Addendum No. 1

RE: Contract # C203977

Johnston County (I-5781)

I-40 From SR-1010 (Cleveland Road) To West of SR-1211 (Morgan Road)

**TYPICAL SECTION NO. 1**

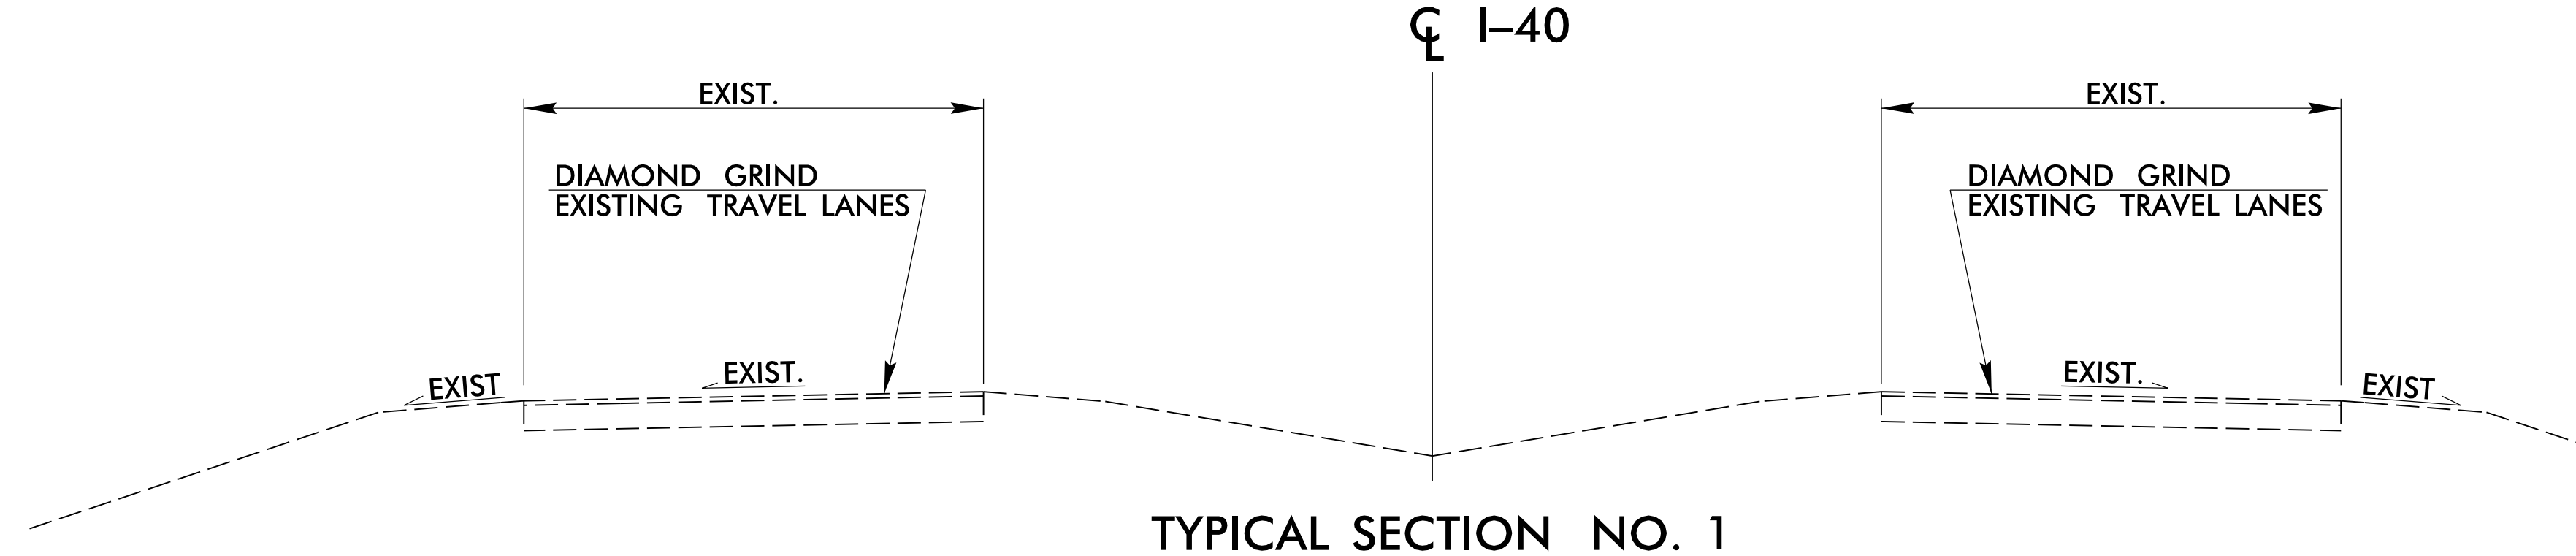
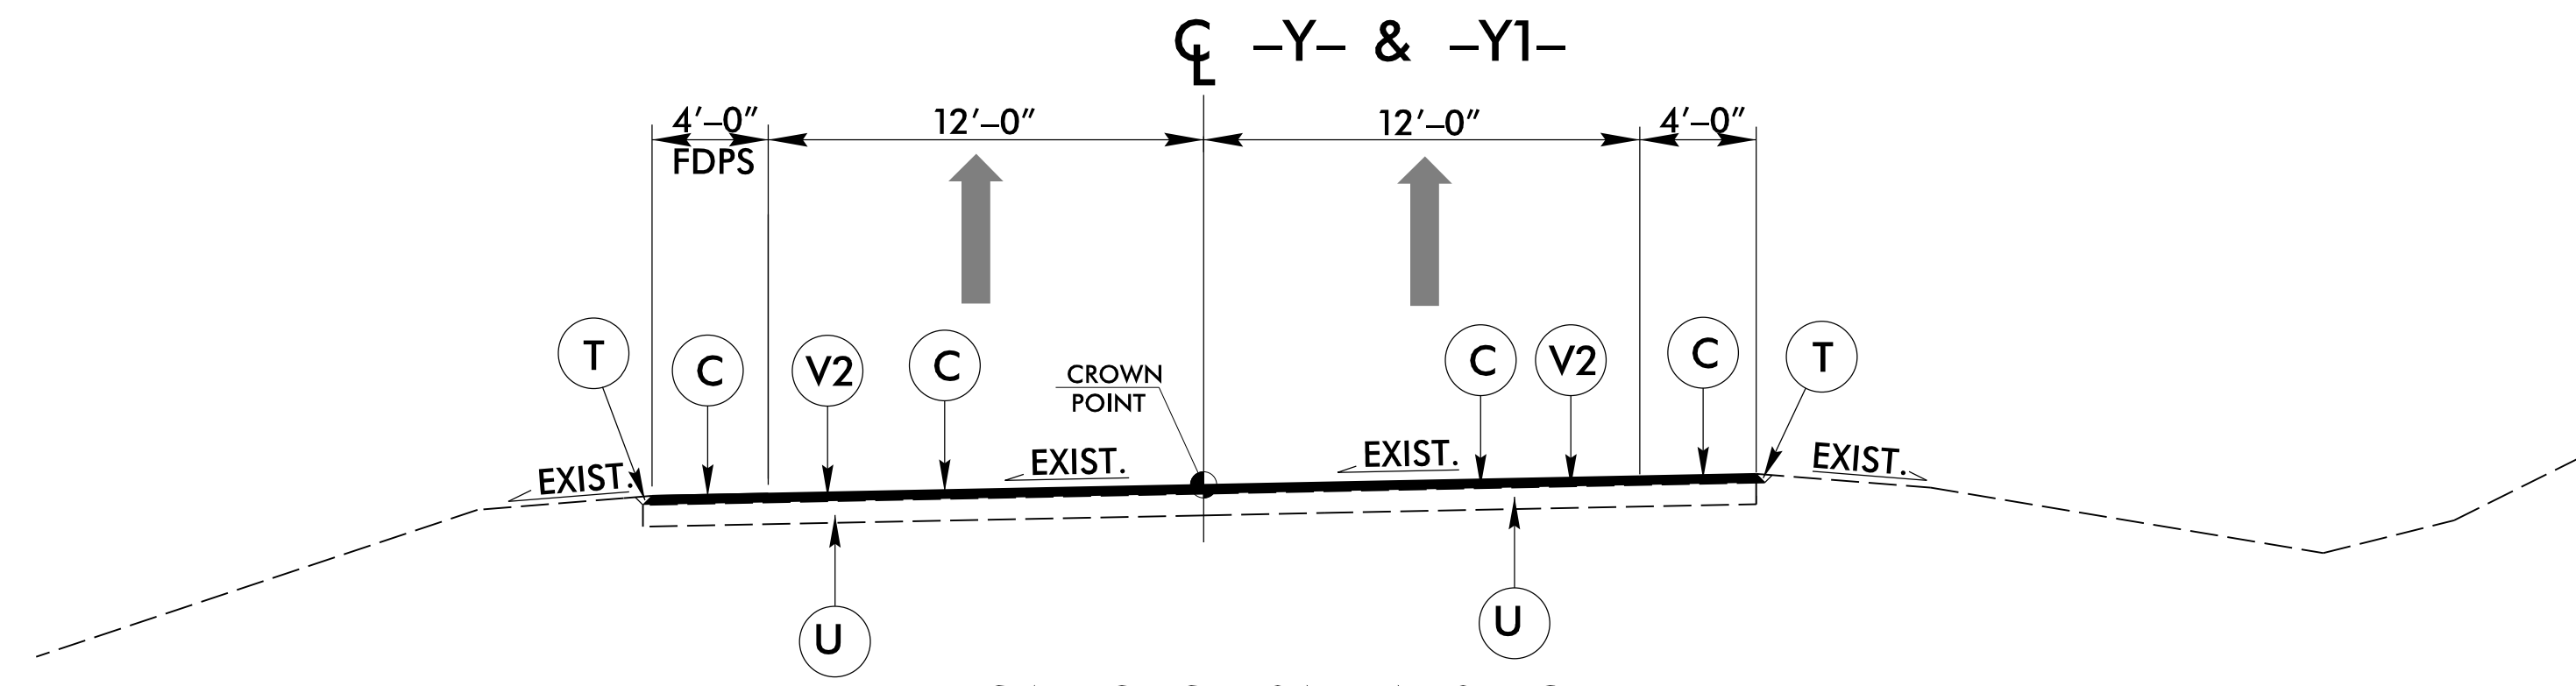
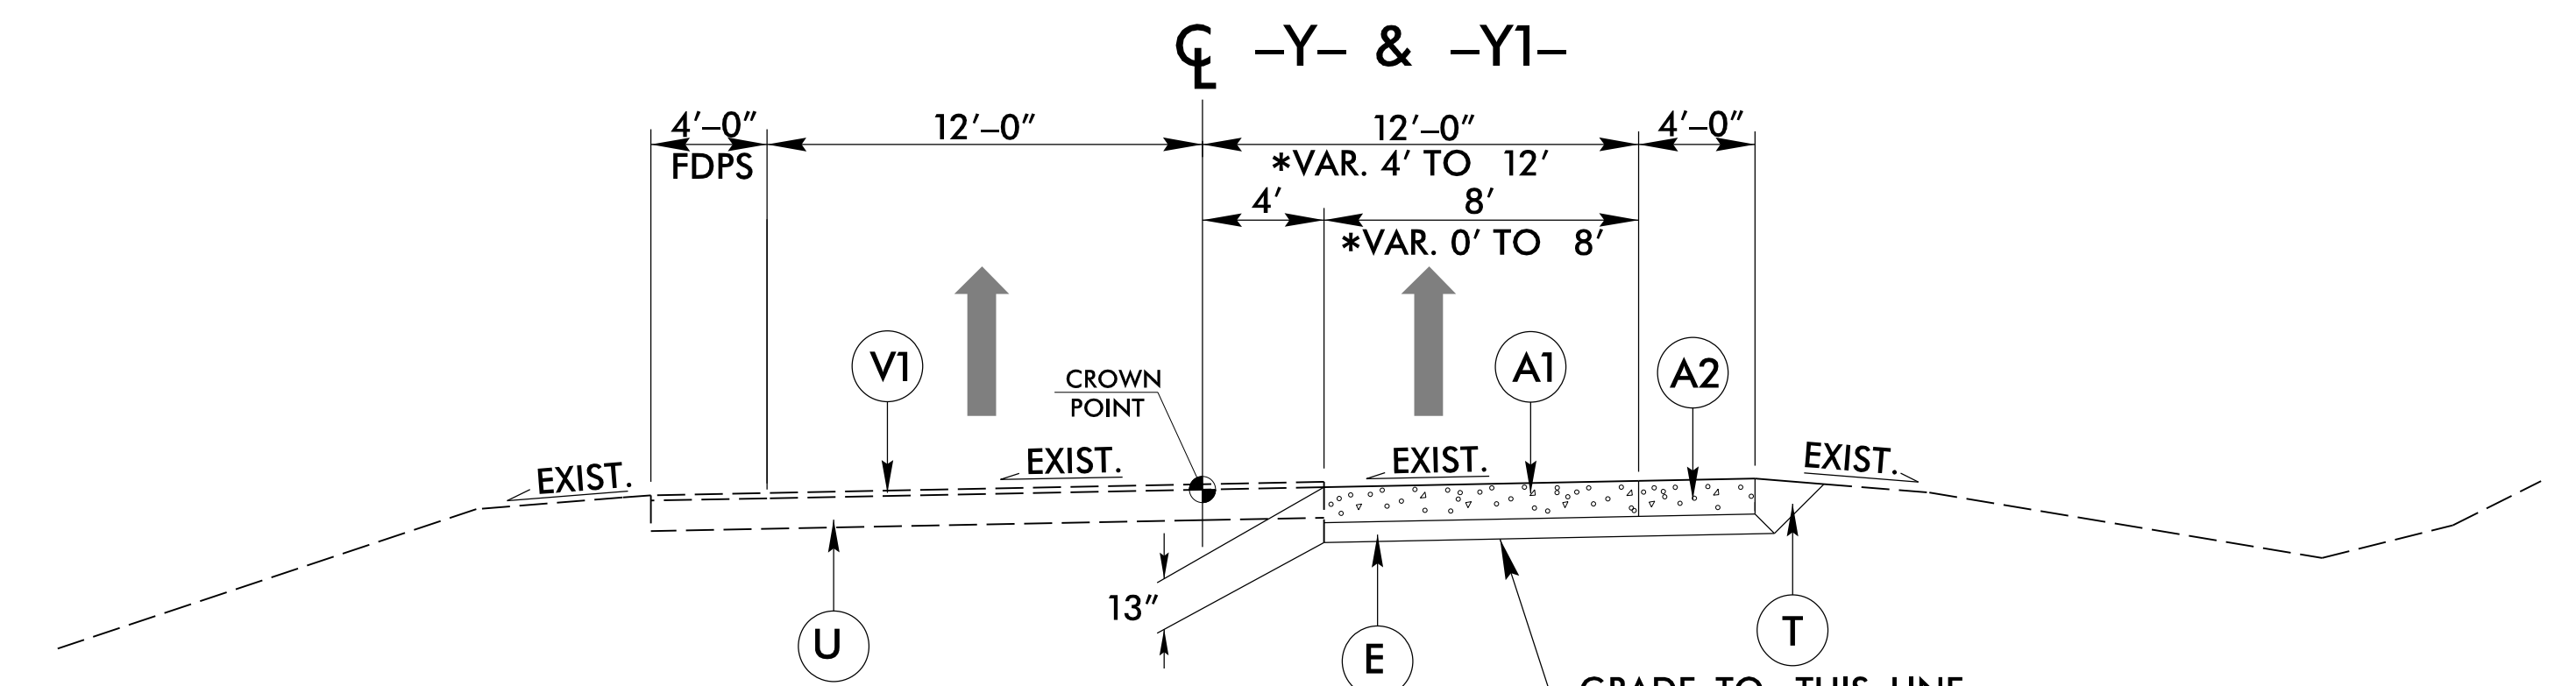
Sheet No.	Revisions
2A-1	Revised to add Note #5
PMP-1 and PMP-2	Revised to reflect the change in pavement markings as noted below
